Bramford to Twinstead Reinforcement

Document 6.6: Scoping Opinion

Proposed Bramford to Twinstead Overhead Line Project

Case Reference: EN020002

**FIGURE 1.1**

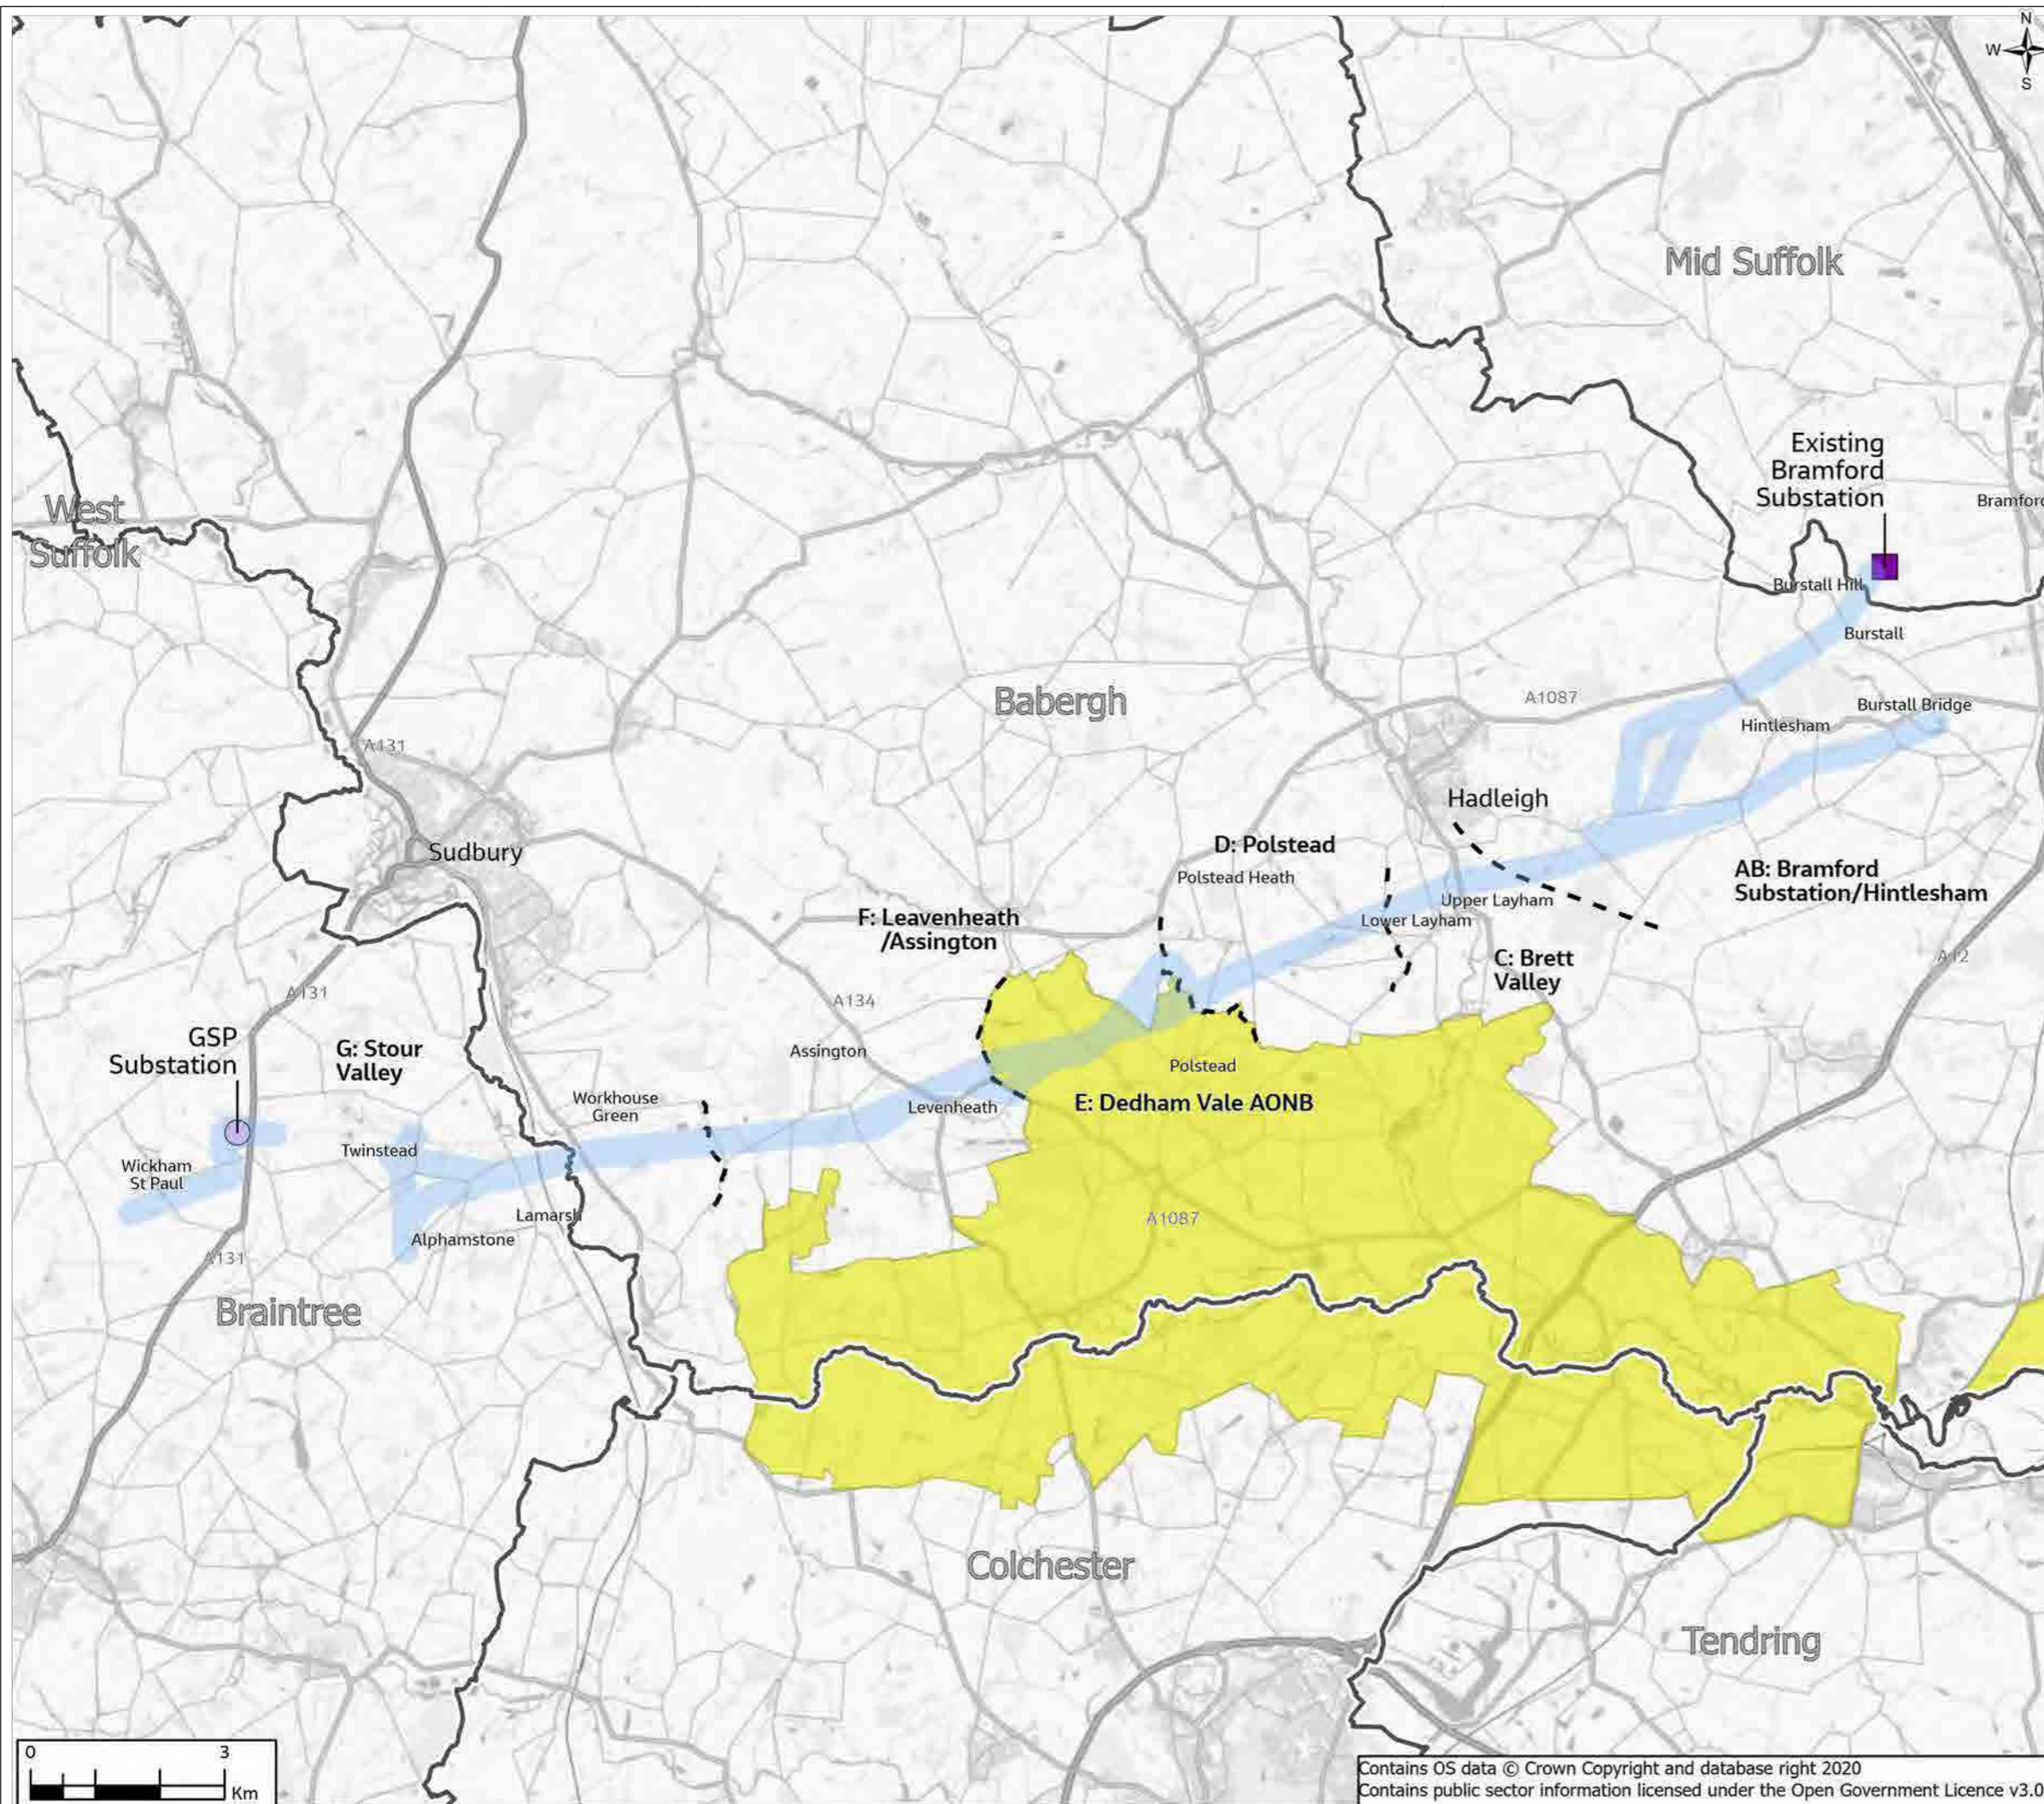
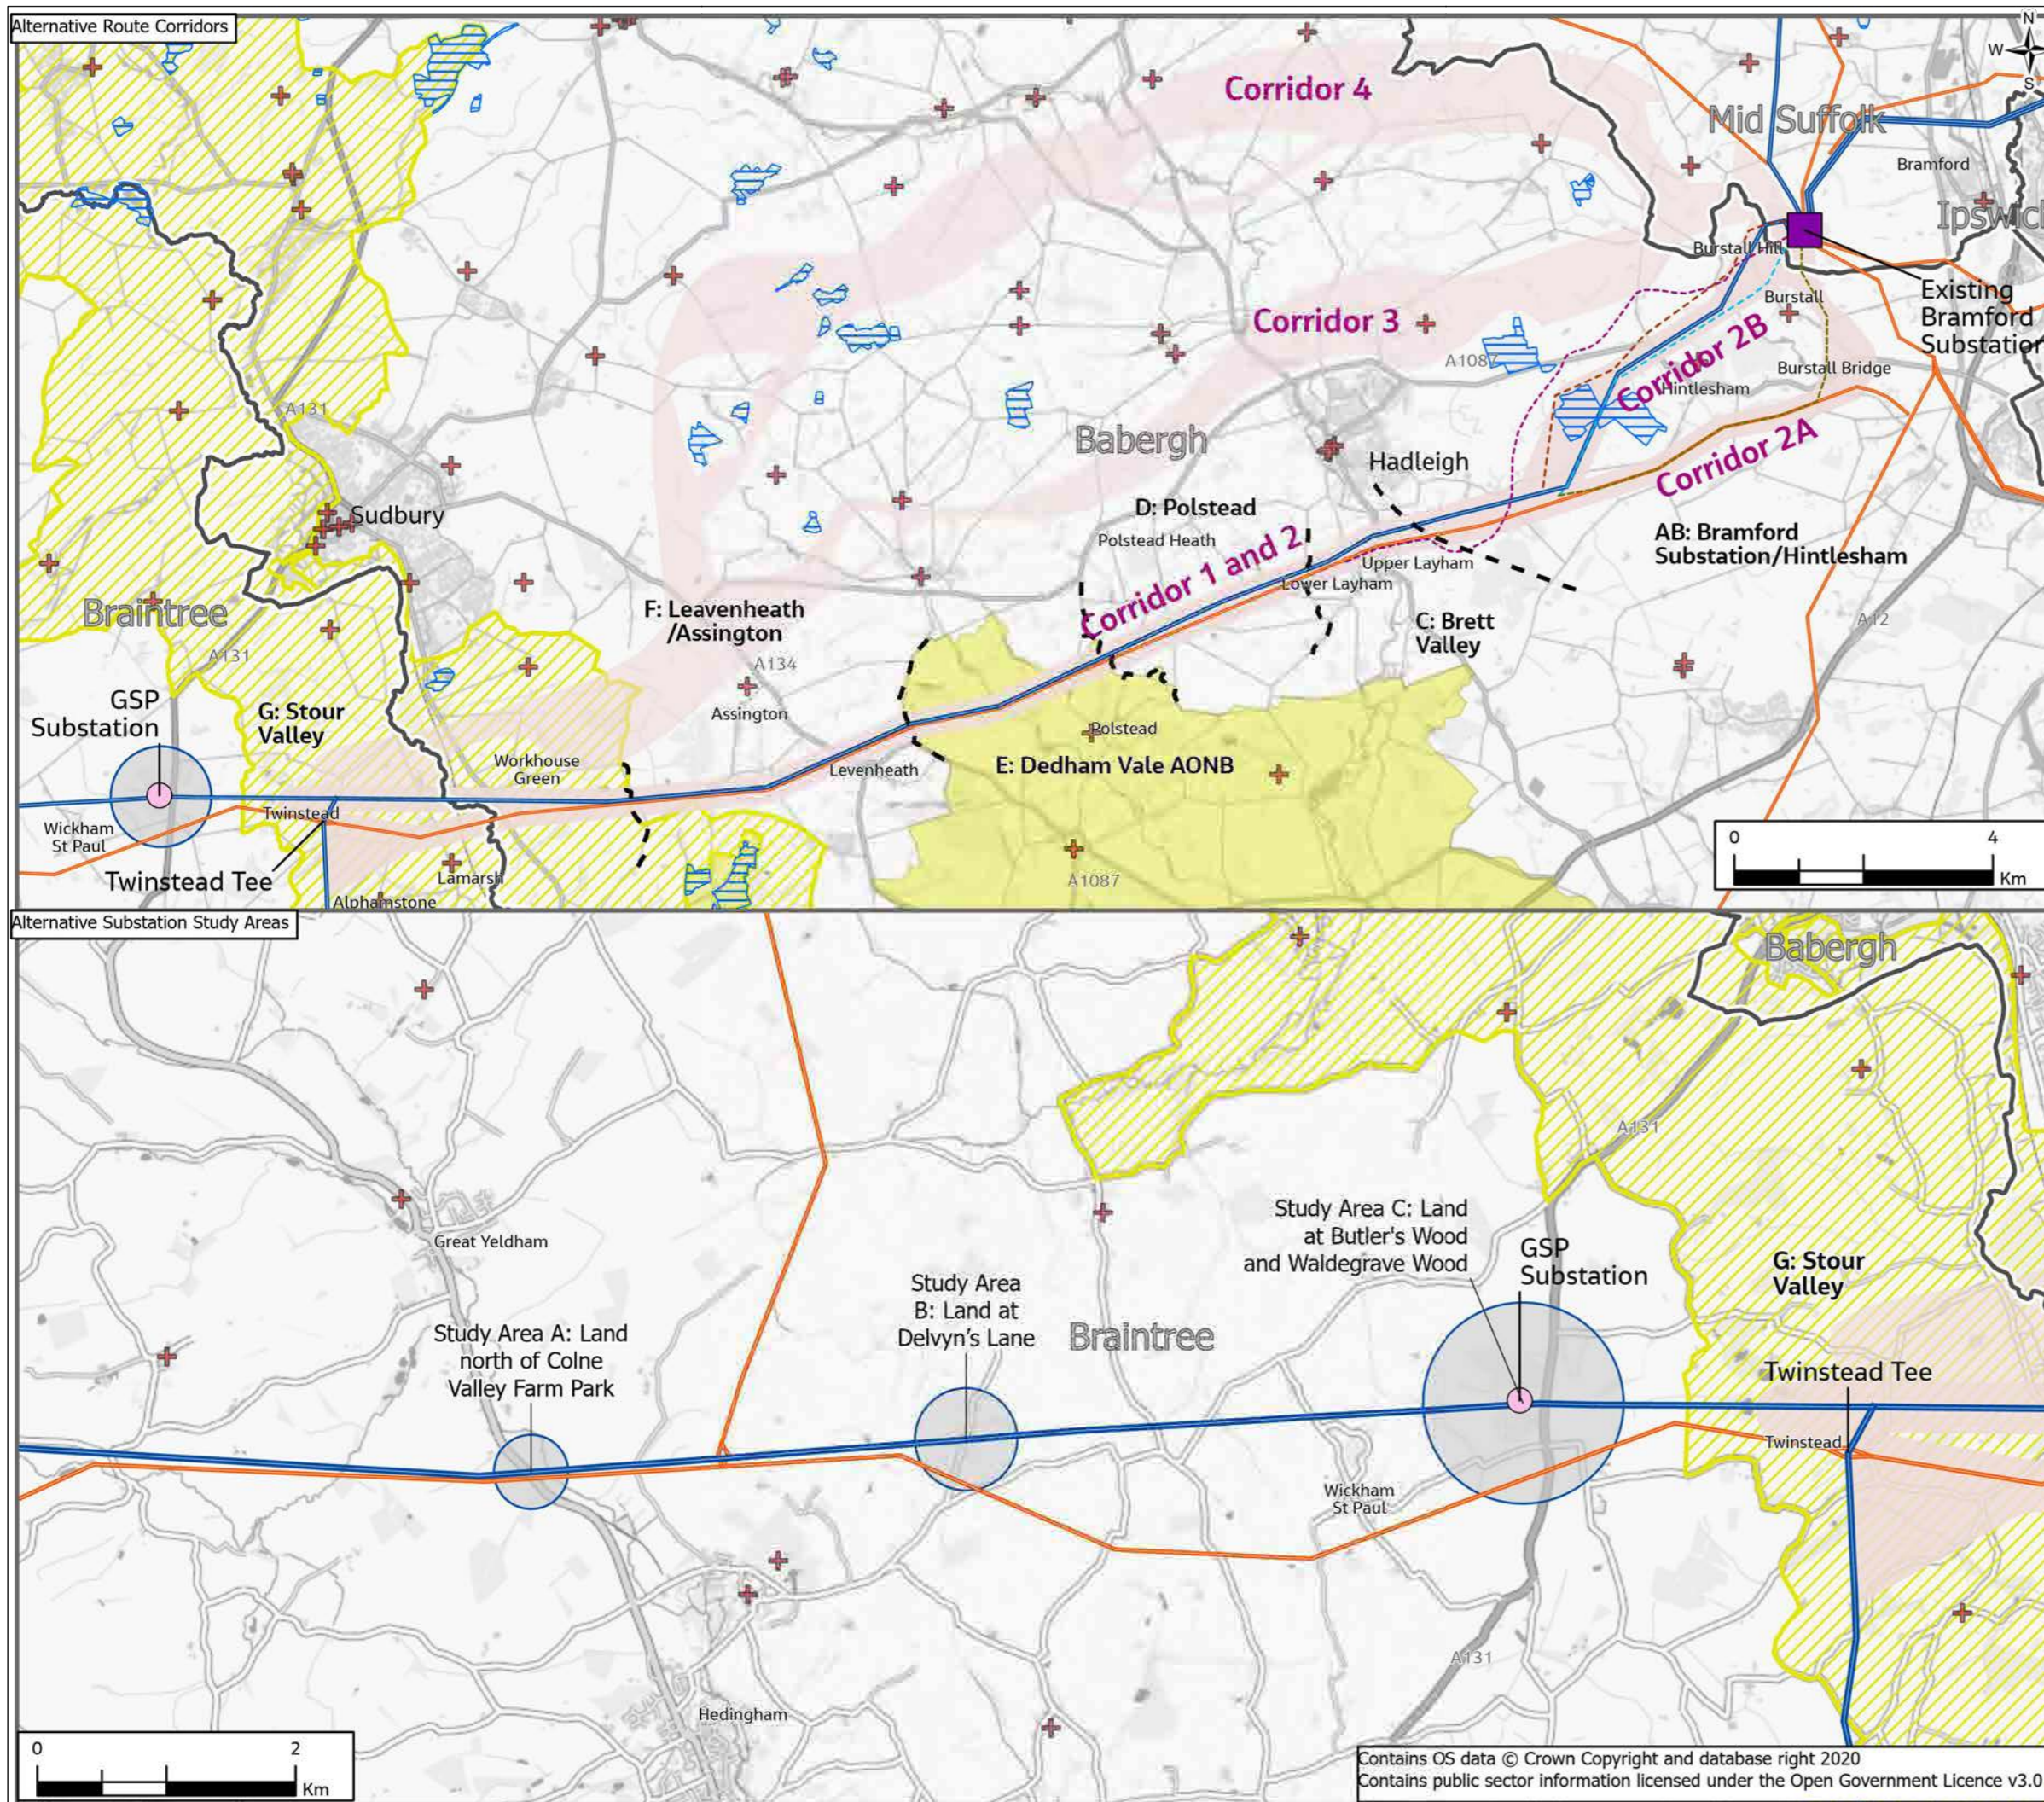
- 2.2.7 A location plan is provided at Figure 1.1 (Volume 3) (drawing reference AAA_B2B_01_Introduction). The Applicant has stated that the boundary for the purposes of EIA Scoping has been drawn with a 250m buffer to incorporate flexibility for potential refinement of the indicative alignment of the OHL forming part of the Proposed Development. It is stated at paragraph 1.1.5 of the Scoping Report (Volume 1) that the order limits will be further defined and will replace the scoping boundary as the basis for assessment in the ES.

- 2.2.8 The scoping boundary is divided into six sections based on landscape character areas, which the Applicant states have informed the options' appraisal for the Proposed Development. The sections are shown on Figure 1.1 (Volume 3) and are as follows:
